**Our ref:** NO/2019/111994/02-L01  
**Your ref:** 3/2019/0356  
**Date:** 14 November 2019

**DEMOLITION OF EXISTING FARM HOUSE AND ERECTION OF REPLACEMENT DWELLING. CHANGE OF USE OF BARN TO ONE LIVE/WORK UNIT INCLUDING CONVERSION OF AN EXISTING BUILDING TO GARAGE. DEMOLITION OF EXISTING FARM BUILDINGS. (RESUBMISSION OF APPLICATION 3/2018/1081). STARTIFANTS FARM GOOSE LANE, CHIPPING, PRESTON, PR3 2QB.**

**Environment Agency position:**

Project Number:	Date:	Scale:	By:
351A/201	Jul/18	1:200	JH

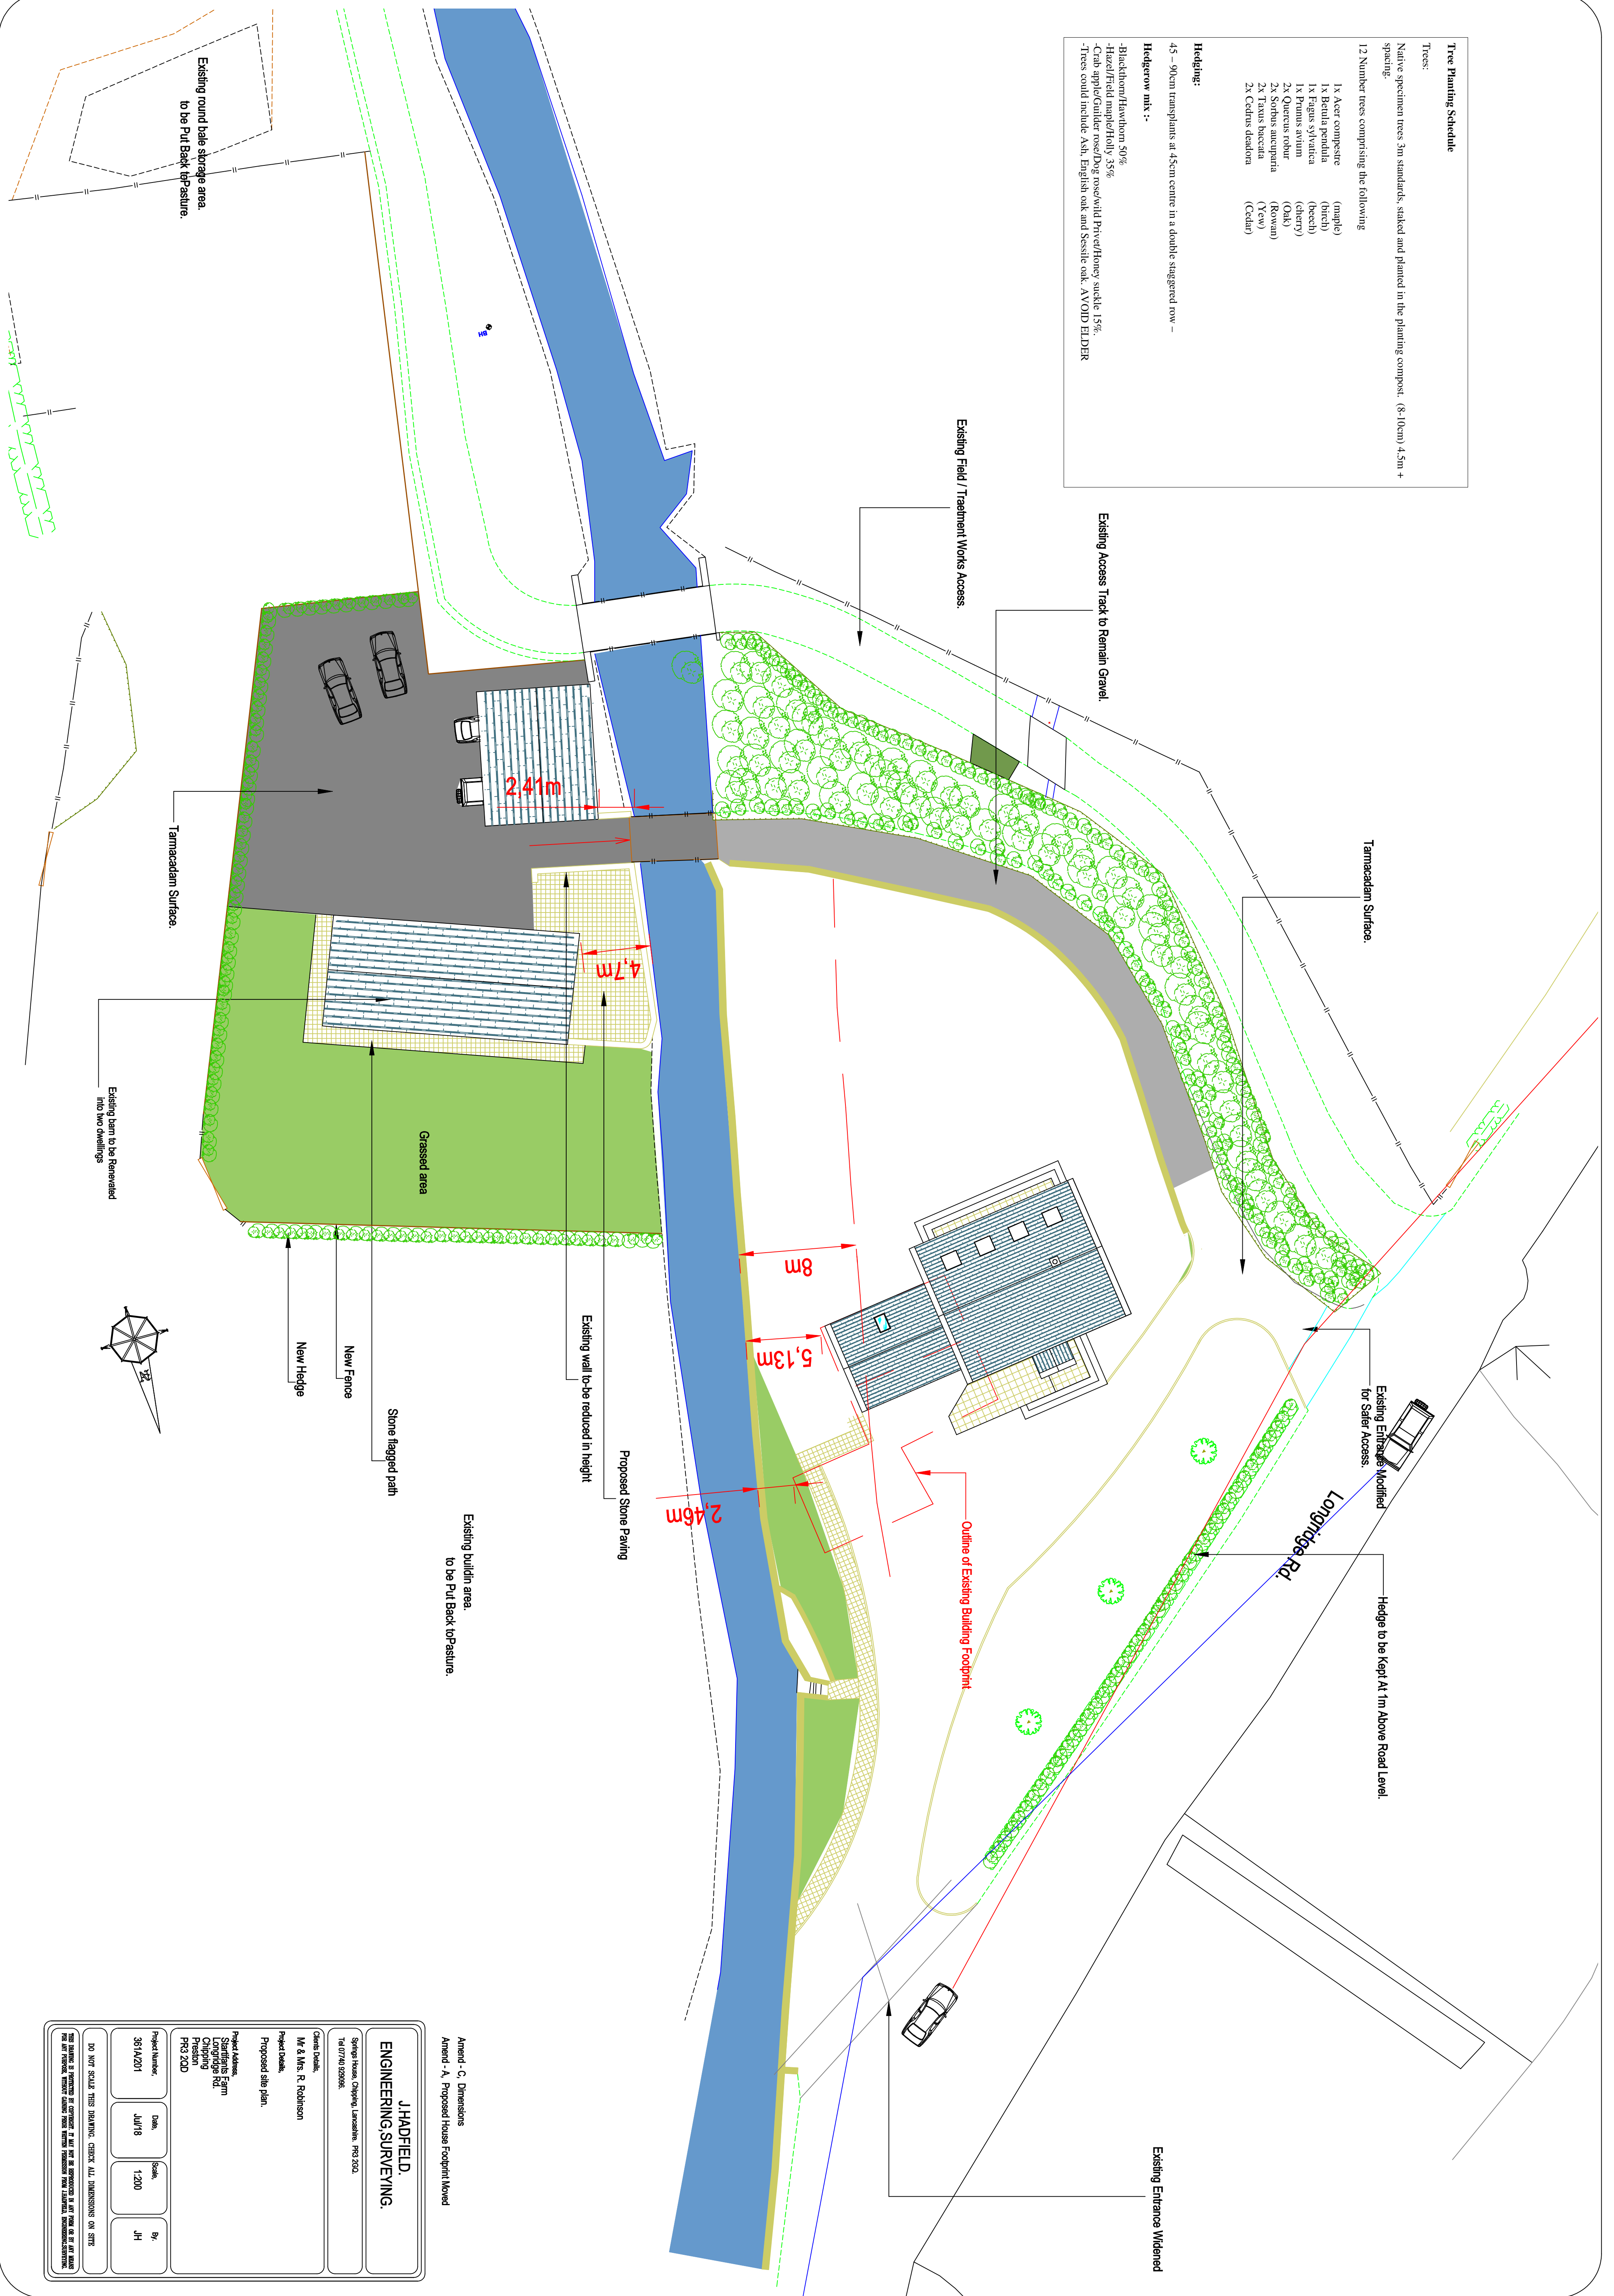
The applicant has provided a Proposed Site Plan, referenced 361A/201, Revision C, to show the proposed development in relation to the top of bank of Chipping Brook which is designated as a Main River. We are satisfied with the proposed site layout however the proposed development includes the demolition of a number of buildings

within 8metres of Chipping Brook and therefore, the applicant will require an Environmental Permit for any works within 8 metres of Chipping Brook. The guidance governing Environmental Permits can be found below:
